15 December 2016
Our Ref: N26522
Your Ref: DA 485-12-2002 MOD 1

**REQUEST TO MODIFY A DEVELOPMENT APPROVAL UNDER SECTION 75W OF THE EP&A ACT _
DEVELOPMENT APPLICATION 485-12-2002 MOD 1 - MODIFICATION TO RESIDENTIAL SUBDIVISION AT
NADINE STREET, SANCTUARY POINT**

Comments on Agency & Public Submissions

TYPICAL 5m ROAD 01 CROSS SECTION
SCALE 1:50

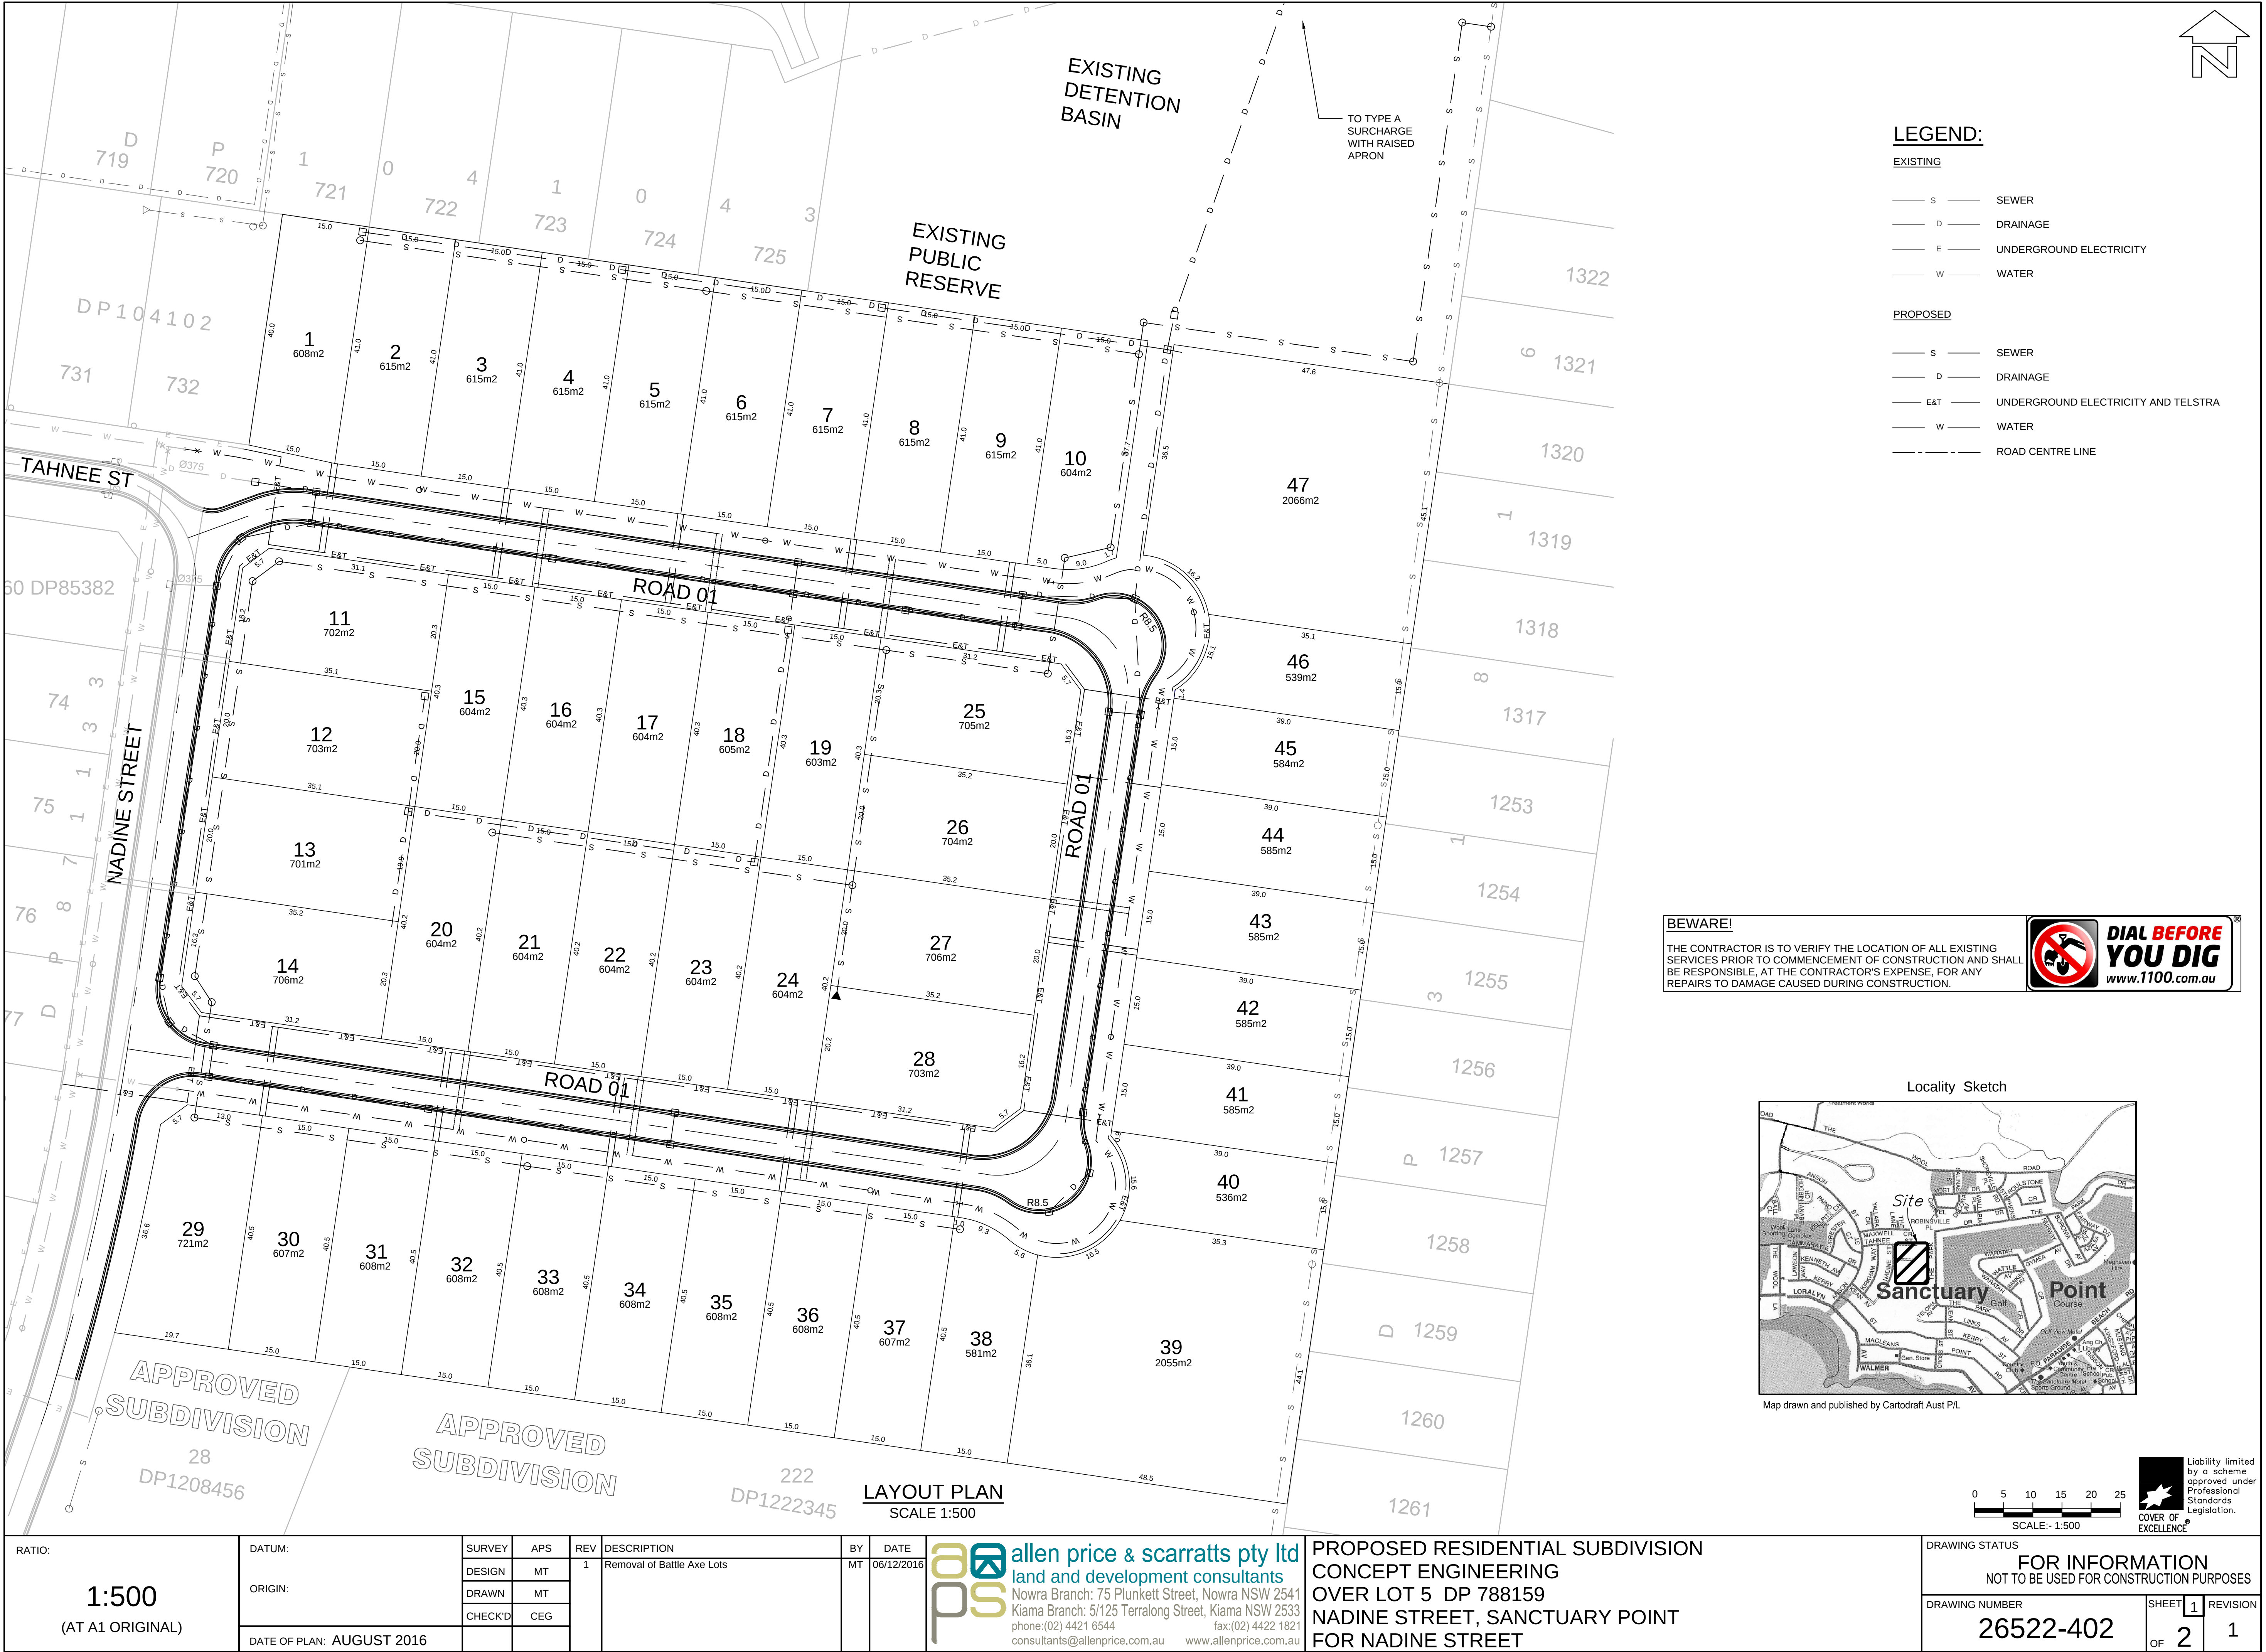
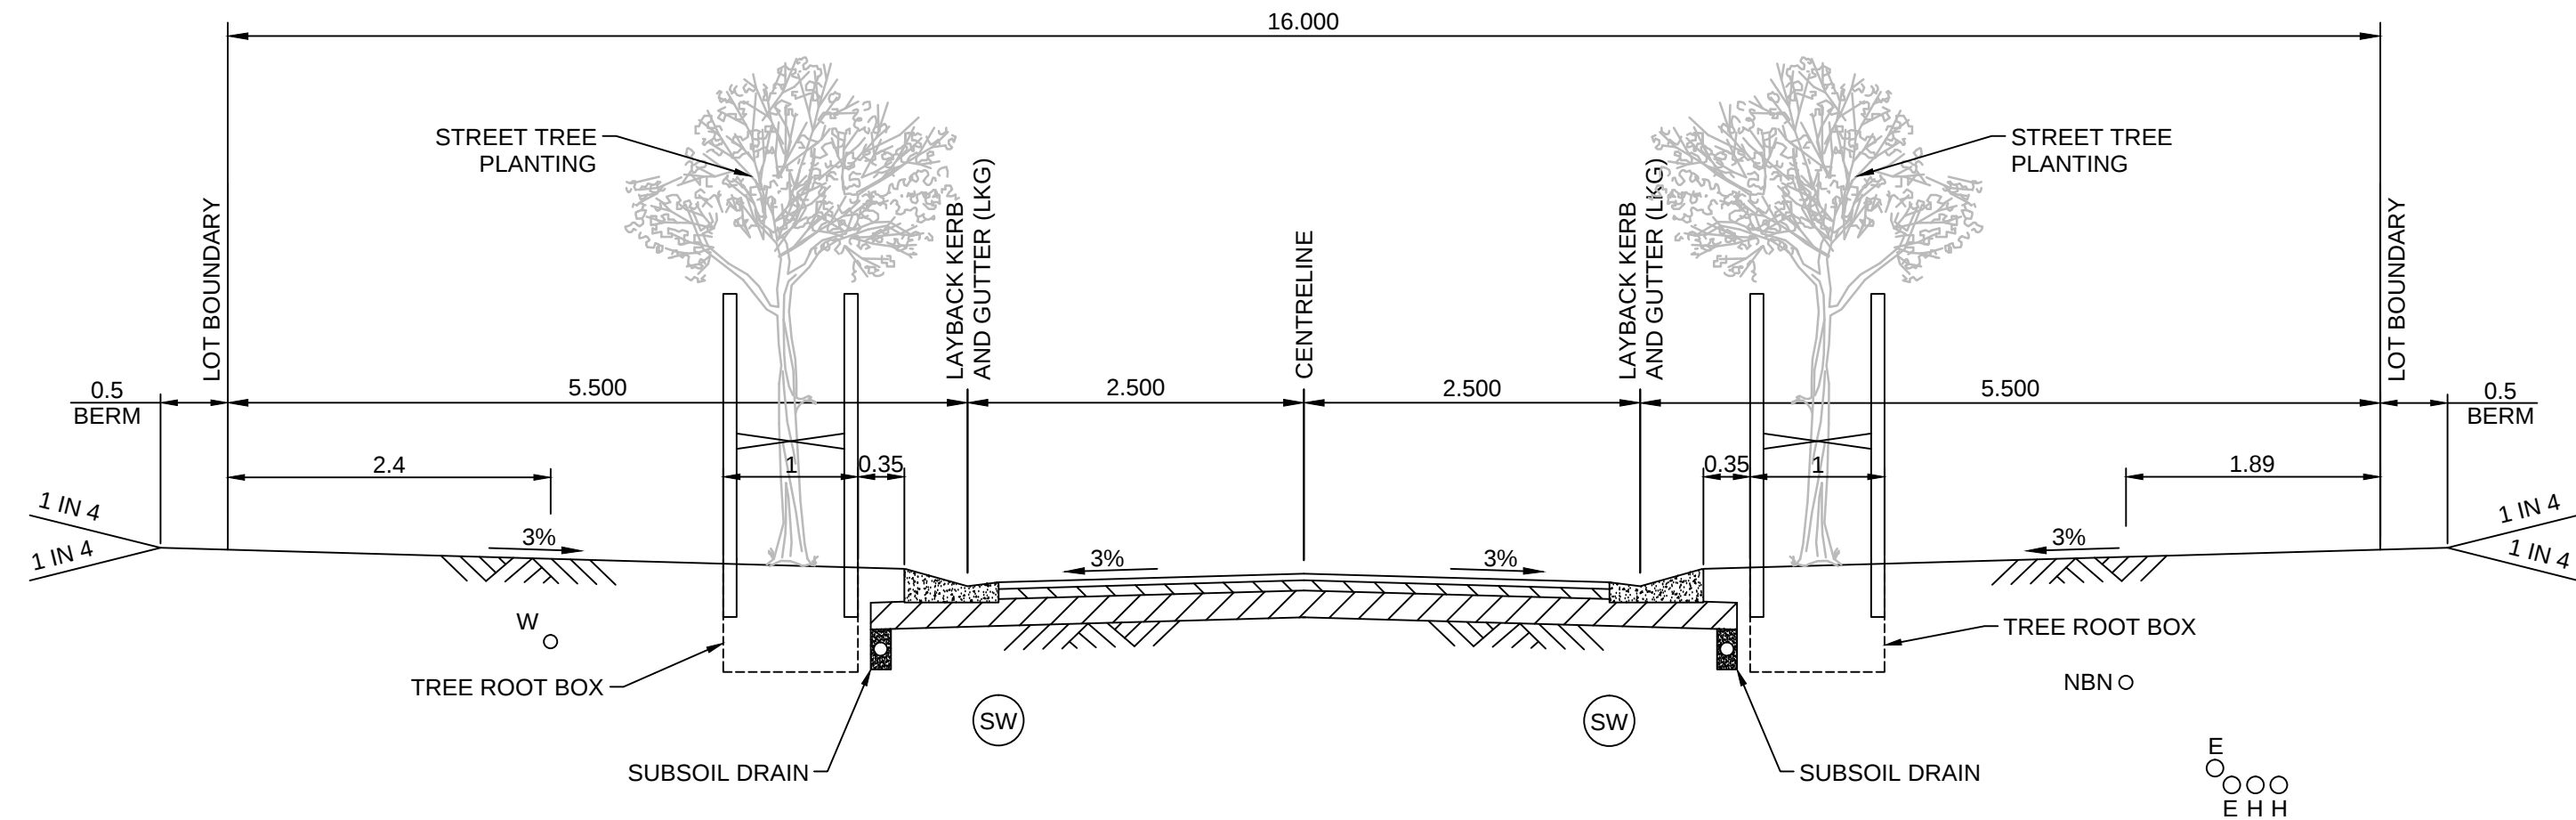
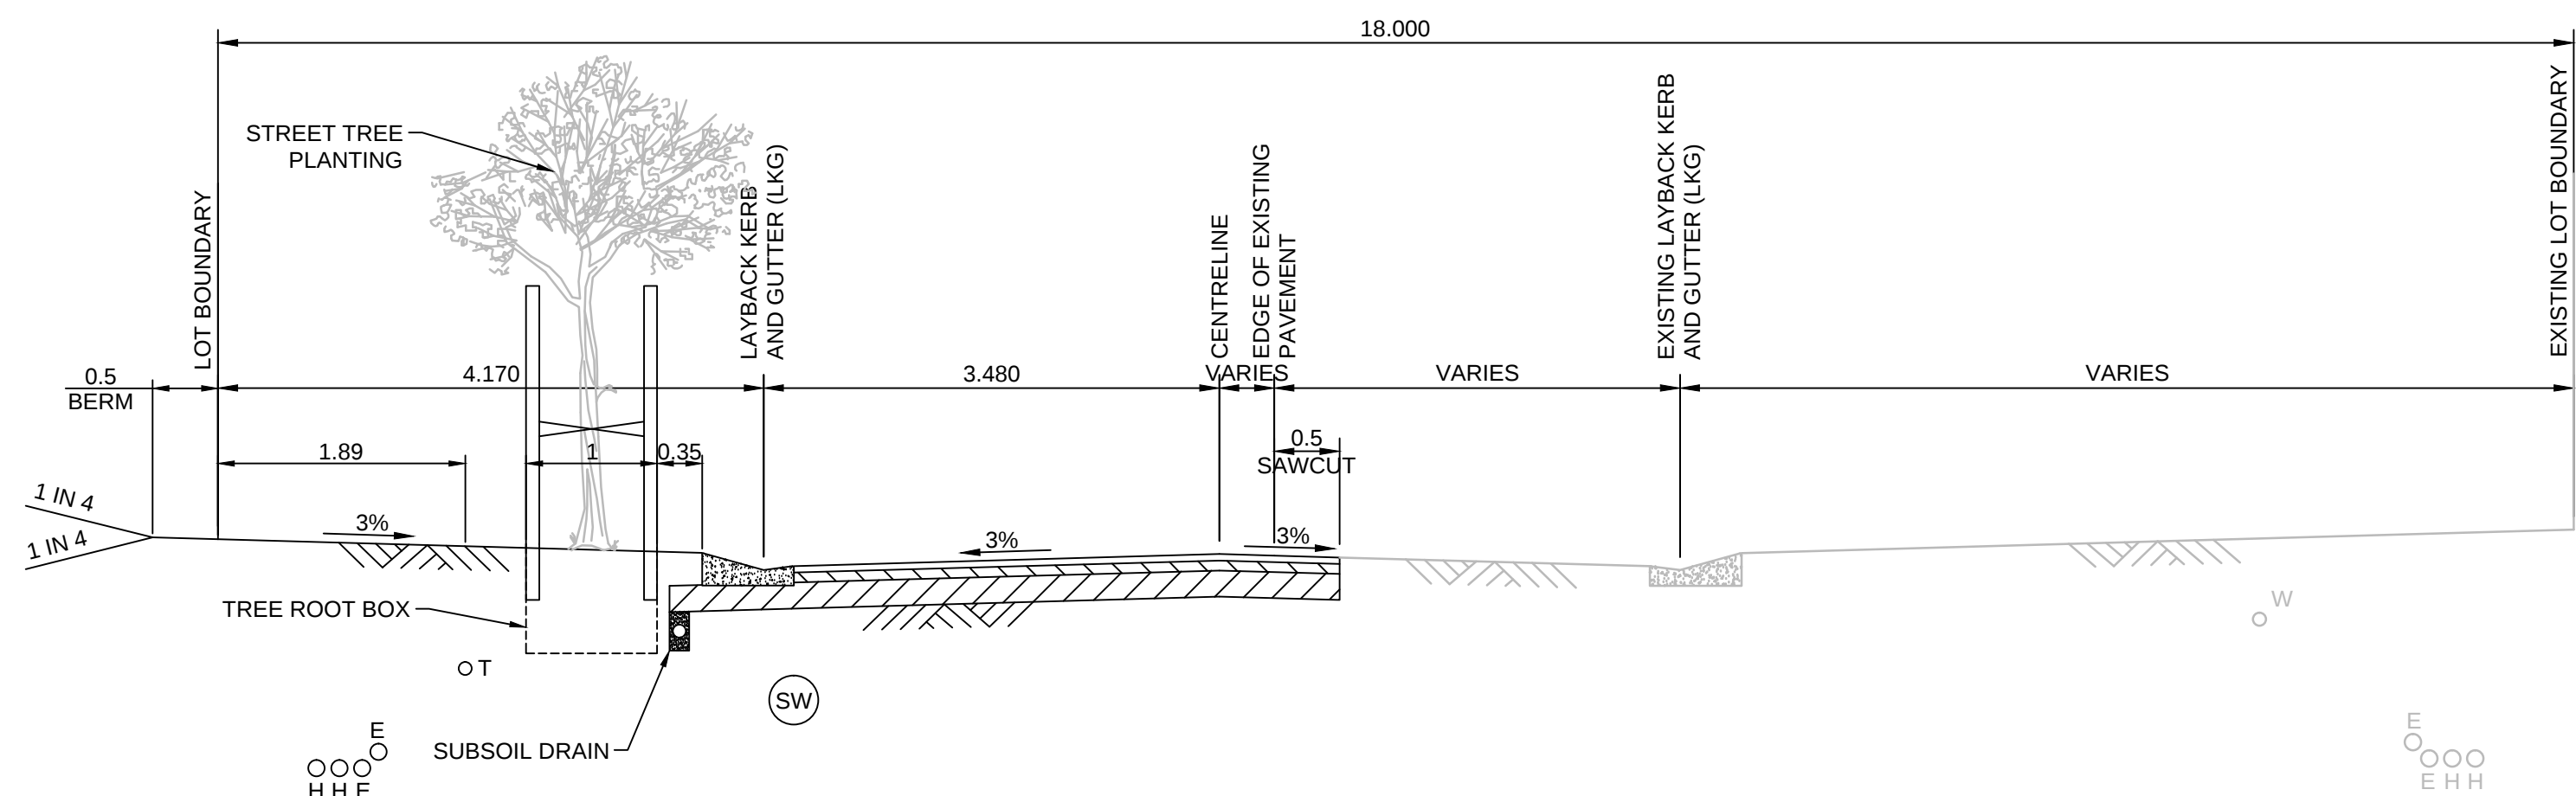
Agency	Detail of Issue	Response to Submission
	<p>88B plans and or readily available for the plumbers during construction (maybe required to be on the approved plans). An 88b should include a requirement to restrict plumbers from cutting in their own connection point or provide instruction of how the connection point/s are to be constructed.</p> <ul style="list-style-type: none"> • Roads and Access - Road widths have been reduced from 18 to 16m and a through road created from Nadine St (18m wide) to Tahnee St (18m wide). Reduced road widths constrain opportunity for on street parking and landscaping. Increasing lot numbers and reducing the size of lots increases demand for on street parking. <p>The 'knuckles' must accommodate garbage trucks and emergency service appliances.</p> <p>Supporting details such as, verge widths, pavement widths, radii of 'knuckles' and cross sections showing</p>	<p>the work as executed plans. An 88B Instrument relates to easements and restrictions – it is not a construction or WAE plan. The location of junctions are never shown on 88B Instruments in the Shoalhaven area.</p> <ul style="list-style-type: none"> • It is proposed to reduce the width of the road reserve from 18m to 16m, which complies with the requirements of the Shoalhaven Development Control Plan (DCP) 2014. The road carriageway width remains unchanged at 5m, as conditioned within the original development consent. Given that parking of motor vehicles is not permitted within the road verge, the proposed change to the verge width does not reduce available on-street parking. <p>Sufficient parking can be provided within each allotment and assessed at dwelling application stage in accordance with the relevant legislation. Complying Development may be an option as the proposed residential lots are suitable in size and shape to accommodate Complying Development.</p> <ul style="list-style-type: none"> • Knuckles have been amended to accommodate for a garbage truck and emergency services vehicles. It should be noted that given the road is now a through road, vehicles are not required to turn around in the knuckles, which improves the flow of traffic within the locality. • Revised concept engineering plans detail information regarding verge widths, location of services and landscaping and radii of the knuckles.

Agency	Detail of Issue	Response to Submission
	<p>location of serves and landscaping have not been provided.</p> <ul style="list-style-type: none"> • Consideration should be provided to additional onsite parking as the smaller streets have the ability to create congestion. • Vegetation Removal - A vegetation retention plan has been approved and is being carried out under Council Construction Certificate CC16/1533. The vegetation retention plan identifies trees within the currently approved lots. The density of the proposal has increased from 39 lots to 51 lots, i.e. 23.5% increase in lots. In addition, the average lot size of the approved development is 723m² without access handles. The average lot size in the proposed modification is 642m² (without access handles) with 82% of the lots having a reduced lot width of 15m. <p>The size and width of lots in the proposed modification provides very limited opportunity to retain any of the trees identified for retention in the vegetation retention plan. Furthermore, Council does not support deferring the cost of development, that is, tree</p>	<p>Response to Submission</p> <ul style="list-style-type: none"> • The proposed allotments are a minimum of 20% in excess of the minimum lot size of 500m². Numerous home builders with suitable single storey two-garage designs are available to fit on rectangular lots with 15m lot widths. Appropriately designed dwellings with ample car-parking can be adequately through the Development Application or Complying Development stage. • As previously stated, In accordance with development consent no. 485-12-2002, <i>“all trees identified on the lot survey plan for retention are to be retained for the purposes of habitat, except in the case that they present a real and significant risk to life, limb or property”</i>. <p>In order to preserve native flora and fauna and provide an opportunity for tree retention, it is not proposed to remove trees identified for retention as a component of this S75W. Therefore the removal of trees identified to be retained will not take place, unless an updated vegetation clearance and retention plan is approved by Planning NSW.</p> <p>A plan accompanying this response detailing trees proposed to be retained and the new lot layout, confirms that there is no conflict with trees marked to be retained and proposed future dwelling sites.</p> <ul style="list-style-type: none"> • A more recent Vegetation Clearance and Retention Plan has been approved by Chris Ritchie from Planning NSW, as confirmed in an email dated 2 September 2016.

Agency	Detail of Issue	Response to Submission
	<p><i>denude the area of all trees and the wildlife which lives there, some of which have been caught trying to escape from the compounds which they erect.. (overnight and with as much stealth as they can muster).</i></p> <ul style="list-style-type: none"> • <i>ROAD LAYOUT; The roads around these new developments are far too narrow. Any times we are caught in a queue when there is a large vehicle (garbage truck) – very much like a slalom event because nobody can pass, unless they drive up onto another persons property. When we bought our land the graded road was double the width to what it is now and straight. However, when we came to view our new home, the road was curved and vastly narrowed. This is not a good environment for our kids to grow up in.</i> • <i>THIS IS NOT SYDNEY NOR ITS SUBURBS – we left that behind for this wonderful rural and coast lifestyle, which we though was safe. All this was uppermost in our mind along with the safety aspect.</i> <p><i>The roads as currently proposed in this development are even more narrow. This style of road is totally</i></p>	<ul style="list-style-type: none"> • It is proposed to reduce the width of the road reserve from 18m to 16m, which complies with the requirements of the DCP. The road carriageway width remains unchanged at 5m, as conditioned within the original development consent. Therefore, there will be no additional traffic related issues created as a result of road carriageway reduction. • The proposed development is generally consistent with the requirements of the LEP and DCP. Given that the development remains within the same footprint to that of the original approval, it is not considered likely to adversely impact on the amenity of the locality. • It is proposed to reduce the width of the road reserve from 18m to 16m, which complies with the requirements of the DCP. The road carriageway width remains unchanged at 5m, as conditioned within

Agency	Detail of Issue	Response to Submission
	<ul style="list-style-type: none"> • <i>The reduction in road measurements is far too narrow to allow for two way traffic.</i> • <i>This is a tree studded allotment of land – with many native birds & animals including kangaroos that will suddenly have their natural habitat totally destroyed in one major blow.</i> • <i>adjacent to this development and we also have very narrow streets with no footpaths in our area either. Without having any footpaths - all our local residents find that it is quite dangerous to try and walk for exercise, walk the dog, have children ride their bicycles, mothers pushing prams etc. There is barely enough room for 2 cars to pass each other let alone go around a person who also has to use the road. We do NOT want to see a repetition of this in the next development of the above site.</i> • <i>Drainage issues are also a problem for this area – with backyards often left underwater by heavy rainfall. Strong odours are often smelt</i> 	<ul style="list-style-type: none"> • It is proposed to reduce the width of the road reserve from 18m to 16m, which complies with the requirements of the SDCP. The road carriageway width remains unchanged at 5m which complies with Council's DCP at the time it was approved. • No trees are proposed to be removed as a component of this S75W application. Retaining trees identified to be preserved under the original consent presents an opportunity to protect native flora and fauna. • Footpaths/walkways are proposed to be implemented in accordance with condition B2(l) of the development consent. • Drainage for the site has been designed so that peak flows in all storms up to the 1 in 100 year event, will be less than the impact of the pre-development peak flows. Therefore, stormwater runoff generated by the development is not considered likely to adversely impact on property within or surrounding the site.

<p>John and Robyn Cosgrove 119 The Park Drive Sanctuary Point NSW 2540</p>	<ul style="list-style-type: none"> • <i>“My wife and I have been residing at 119 The Park Drive for almost 12 years and knowing that the land behind our backyard was always going to be built on. On original plan approved by Shoalhaven Council it was totally accepted by most local residents. But recent correspondence from State Gov. Planning and Environment to suggest changes to that original plan by increasing the number of lots from 39 to 51 and alterations to road from 18 meters to 16 meters. This leaves us with grave concerns.</i> 	<ul style="list-style-type: none"> • The proposed S75W development proposal remains within the same footprint as what was approved under development consent no 485-12-2002. An additional 8 allotments are proposed, however, due to the development being within the same development footprint, the additional allotments are not considered likely to place additional strain on the existing capacity of the road network. • It is proposed to reduce the width of the road reserve from 18m to 16m, which complies with the requirements of the Shoalhaven DCP. The road carriageway width remains unchanged at 5m as conditioned within the original development consent.
